REPORT UPDATE

Application No: CM/16/20/PL

PROPOSAL: Variation of condition 2 imposed under CM/64/19/PL to substitute House Type F floor plans & House Type F elevations.

Drg No: 190725-HT-F1-FP	Rev: A
-------------------------	--------

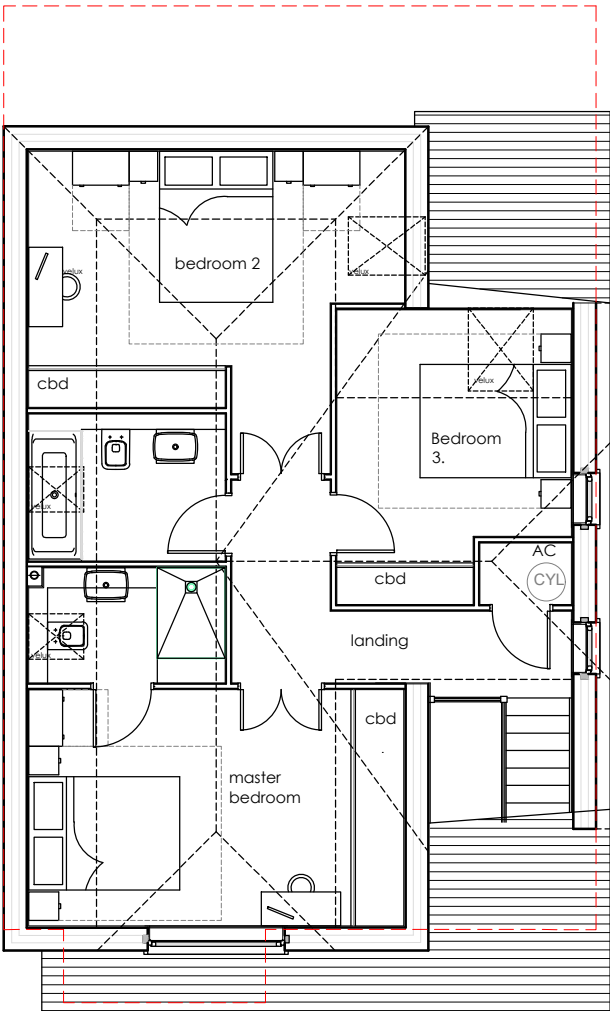
- Fence has been damaged.
- Devaluation of property.
- Length of the proposed house runs the whole length of adjacent boundary, within feet of boundary fence. This is very intrusive, and will obliterate light.
- Object to trees being planted in proximity to boundary. These will be a nuisance.
- House appears to be 1m from the boundary wall.
- To avoid the technical/maintenance issues with a flat roof a pitched roof bungalow could have been considered.

- Proposal is now for a larger house.
- Outlook adversely affected.
- Dwelling will create additional noise.
- First floor windows face directly onto adjoining garden.

- The footprint of the proposed dwelling has not increased.
- The amended dwelling form will not result in a material increase in noise generated adjacent to neighbouring dwellings.
- The proposal does not add any additional first floor windows in the south or east elevation other than roof lights.
- The indicative proposed boundary screening has previously been approved and is controlled by a landscaping condition.

Drg No: 190725/HT-F1-EL Rev: B

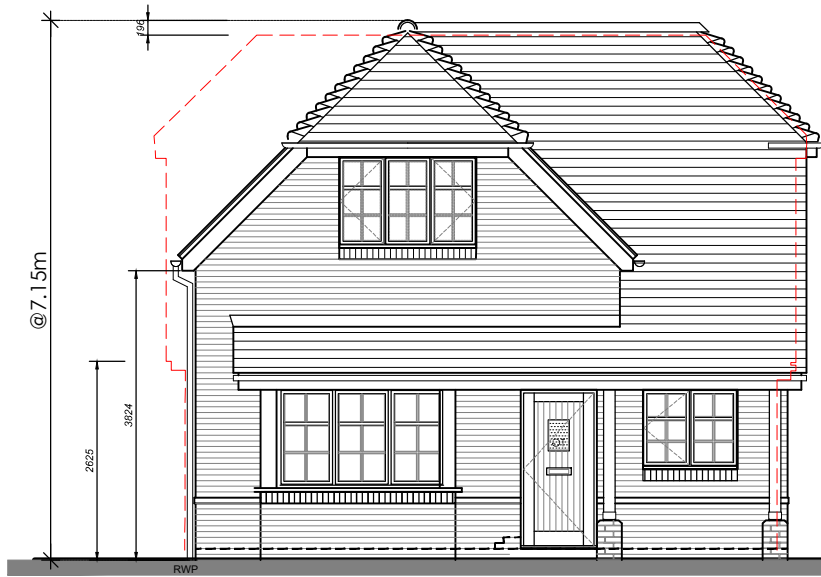
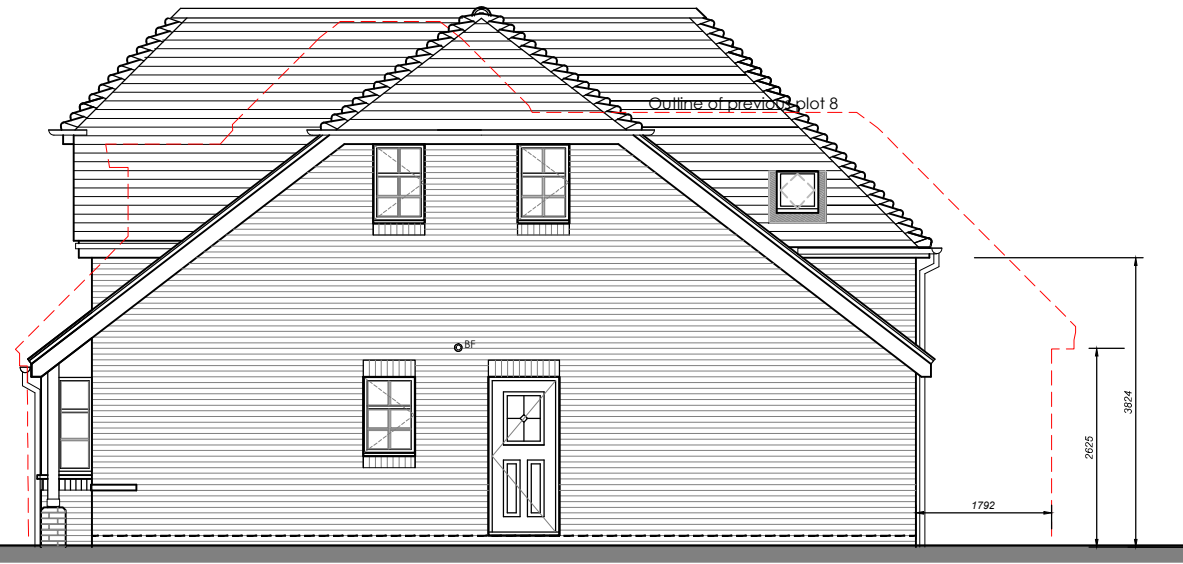
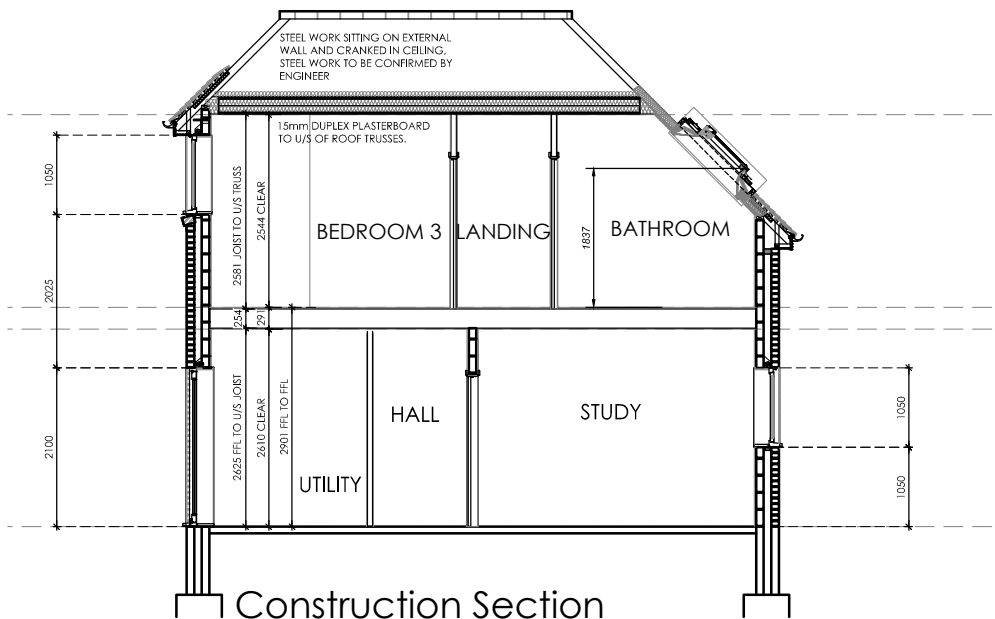
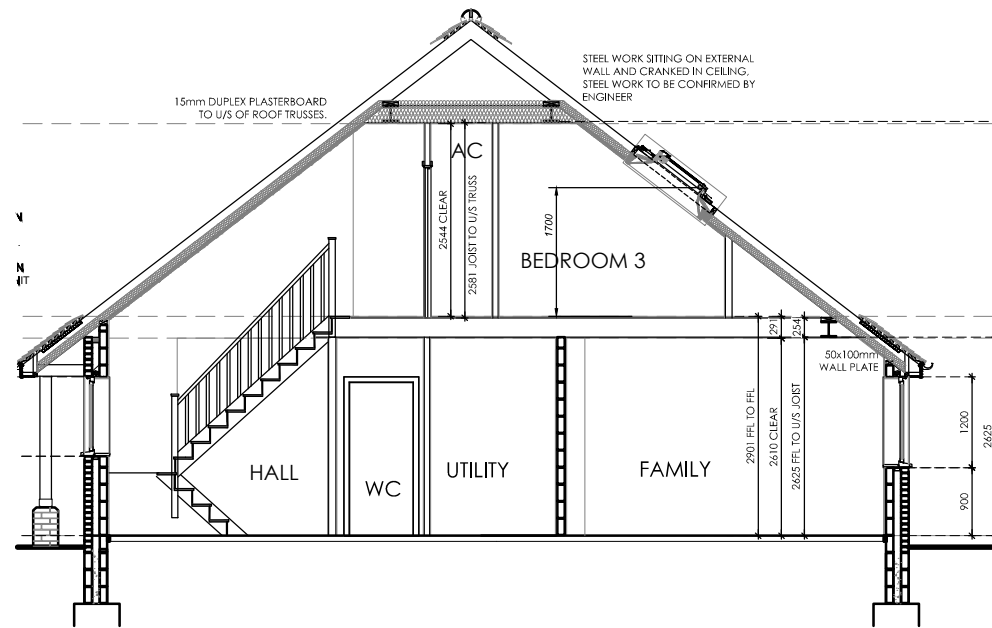
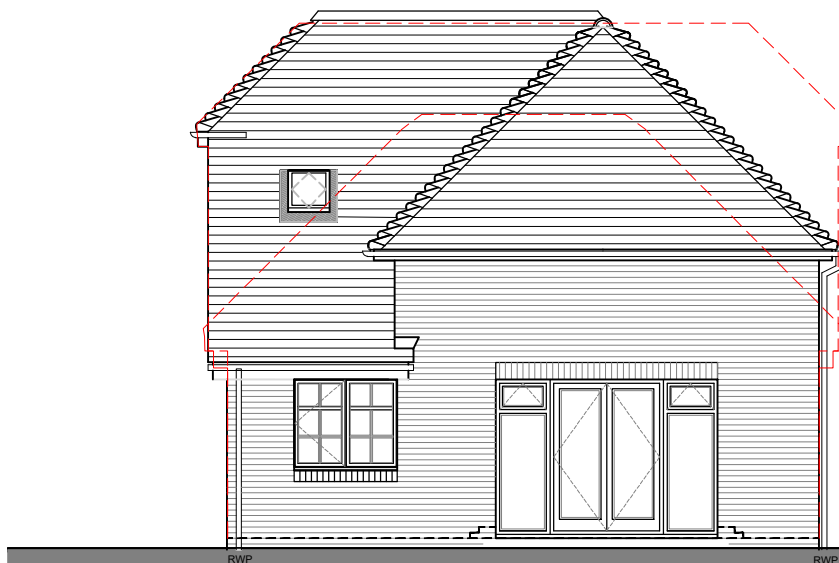
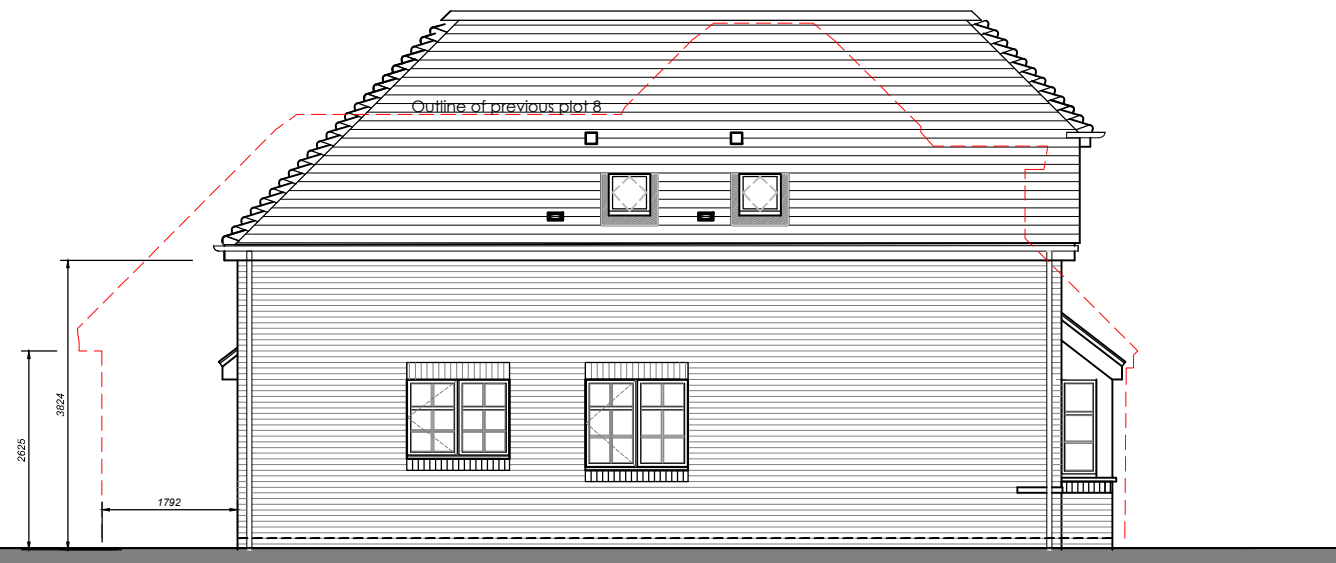
- The roof appears higher and longer. Either the original plans have been altered or the architect has made a mistake drawing in the red dotted outline on the new plans.

- Lack of key measurements such as not stating the pitch and height of the roof or the distance to the boundary.
- Traffic measures ignored with 7 entrances on to HGL in 100 yards.

Clarification was sought from agent to clearly identify dimensions of distances to boundaries and height of proposal on plan and to ensure the super imposed comparative plans accurately reflected the differences between the approved and proposed scheme.

The length of the house is as shown, however the positioning of the plot is relative to the parking bay in front, consequently it is as far north as possible to limit the impact at the rear. To locate the plots, the corner of the window bay is the same in both versions but the posts and overhangs differ in both schemes resulting in the slight difference in appearance/length.

In respect of the dotted roof/ridge lines it appears the representation shows a much lower roof line which is in fact the rear of the previous scheme, whereas the agent has shown the front of the outline of the previous scheme. For clarity, images showing both the front roof and the rear roof superimposed over

the rear elevation have been provided by the agent. The latest drawings are based on a construction/technical drawing to ensure the actual internal dimensions/clearances required are being achieved.
